NORTHPOINTE BUSINESS PARK REZONING

DATE: November 5, 1997
 FROM: Martin R. Cramton, Jr., Planning Director
 TO: Robert Brandon, Zoning Administrator

SUBJECT: Administrative Approval for Petition No. 88-54 by Paw Creek Associates Tax Parcel # 039-211-03

NORTHPOINTE BUSINESS PARK REZONING

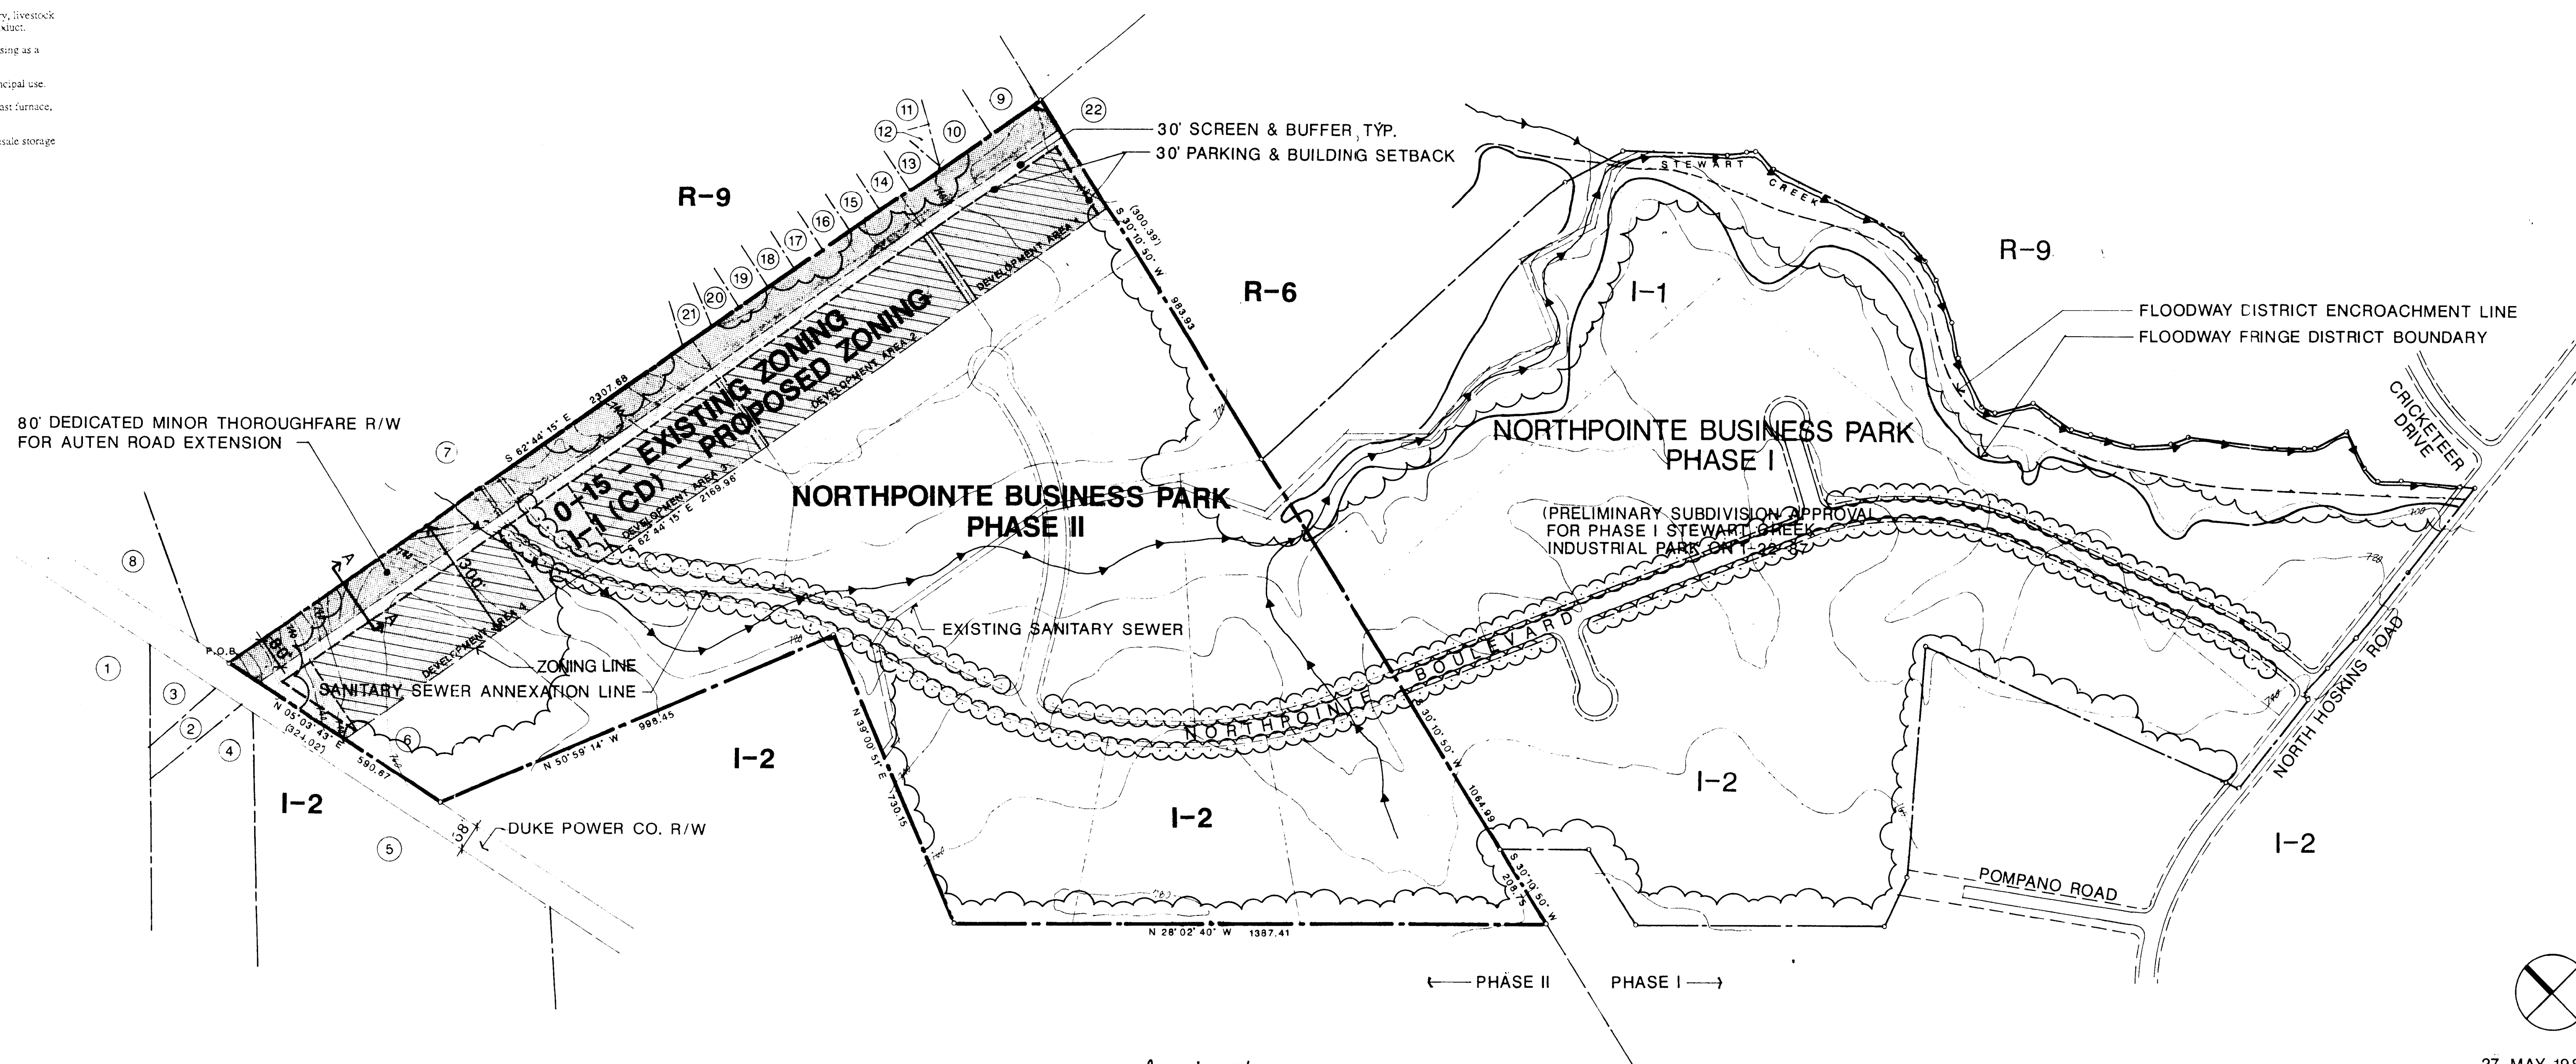
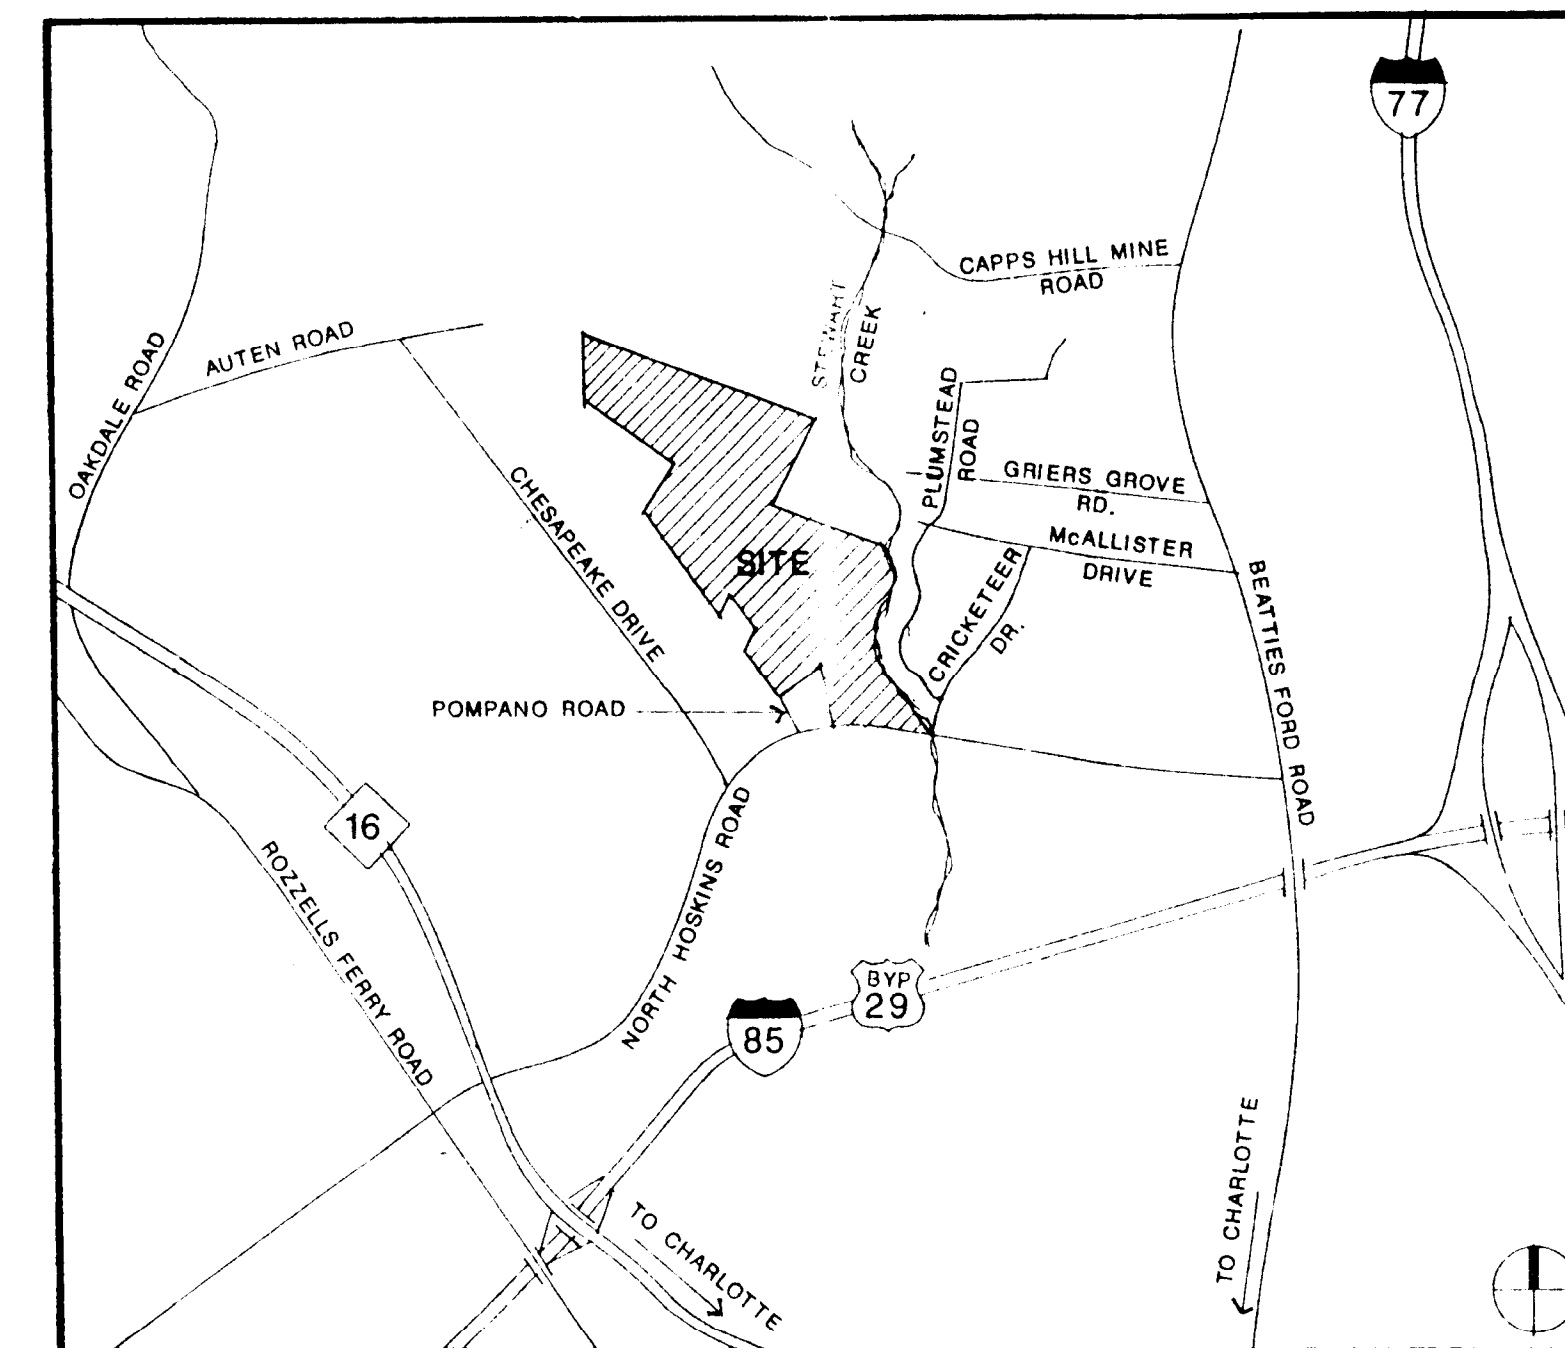
Attached is a revised plan for the above mentioned rezoning petition. The plan has been revised to terminate NorthPointe Boulevard with a cul-de-sac as shown on the attached plan. The lots created at the end of this new cul-de-sac will not have access to future Auten Road. Since this change is minor I am administratively approving this revised plan. Please use this revised plan when evaluating requests for building permits and certificates of occupancy.
